**APPLICATION BY SEGRO PROPERTIES LIMITED FOR THE EAST MIDLANDS GATEWAY PHASE
2 AND HIGHWAY ORDER 202X**

Deadline 6 Submission

EAST MIDLANDS INTERNATIONAL AIRPORT LIMITED

Figure 2: Journey Time Routes (10-20)

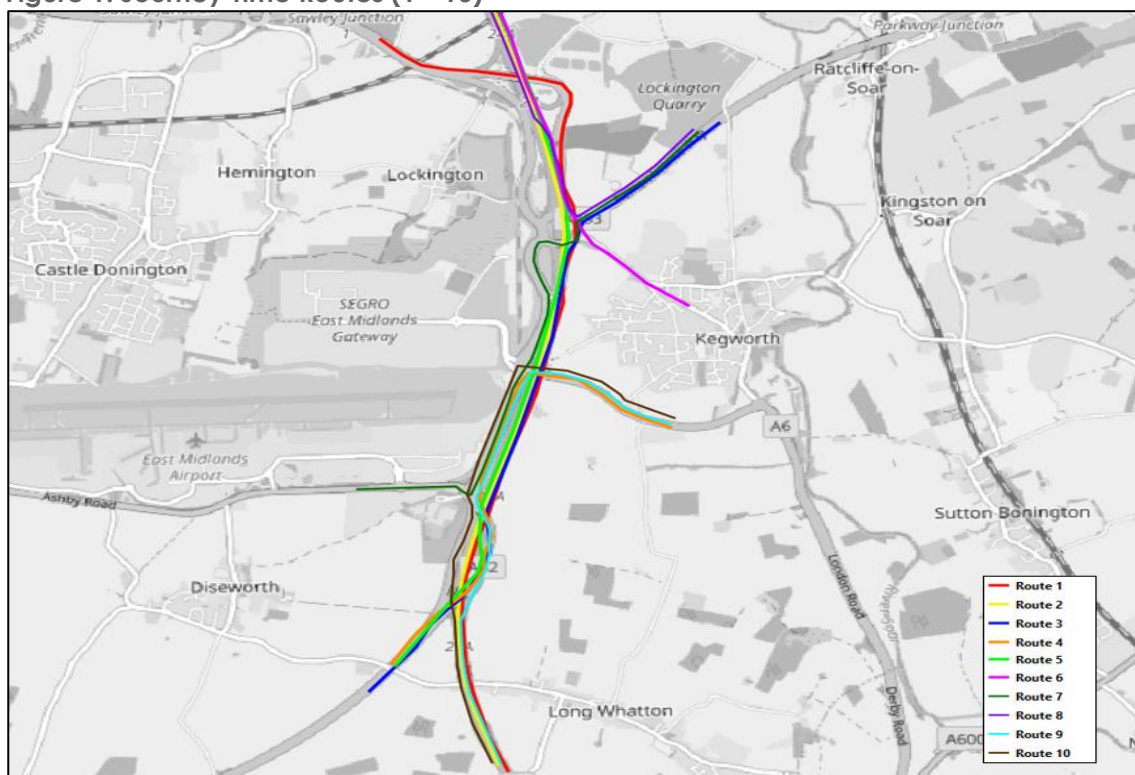
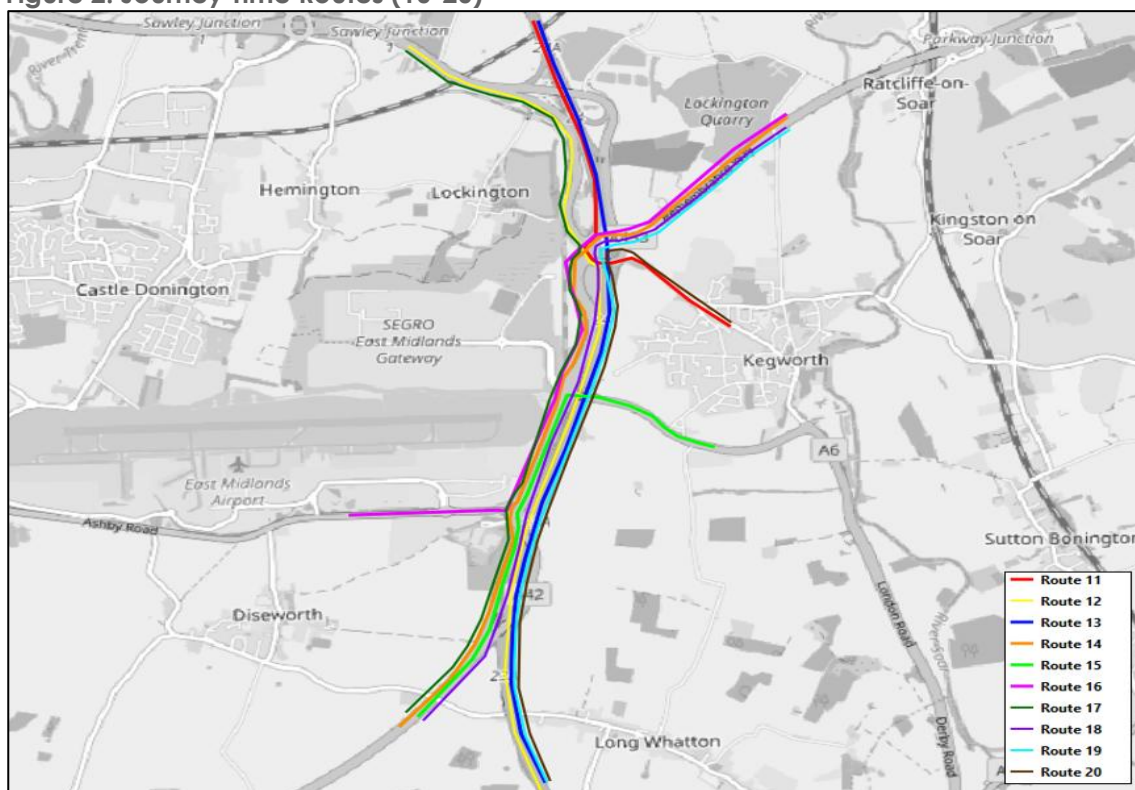
- 4.4 It remains the case that no modelling results have been provided for this junction. As this forms the access point to the site it is critical the capacity of this junction is known as it could affect the operation of the Airport: this roundabout forms one of the key entry points to the Airport and business park and as such its operation is critical.

- 4.5 This junction formed part of the VISSIM model. The model results presented previously by SEGRO, showed results for each junction in the model except this one.

- 4.6 When this data was requested EMA's transport consultants SCP were informed that the *"Queue results are not readily available for the A453/Beverley Road Roundabout because they are embedded in the VISSIM model results"*. This is difficult to understand when this data is available for the other junctions in the model.

- 4.7 When SCP asked the same question again it received a response to indicate that *"the journey time results for Route 16 are relevant to the A453/Beverley Road junction and show a reduction in Stage 2A compared to Stage 1A, highlighting that there would be an overall betterment to the operation of the junction. The latent demand also improves, showing that more traffic is able to enter the VISSIM network in Stage 2A compared to Stage 1A"*. However, again this does not provide a response to the question asked.

- 4.8 It is unacceptable that at this late stage in Examination, SEGRO appear unable to provide the raw modelling results that would enable EMA to satisfy itself on the future operation of this key roundabout.
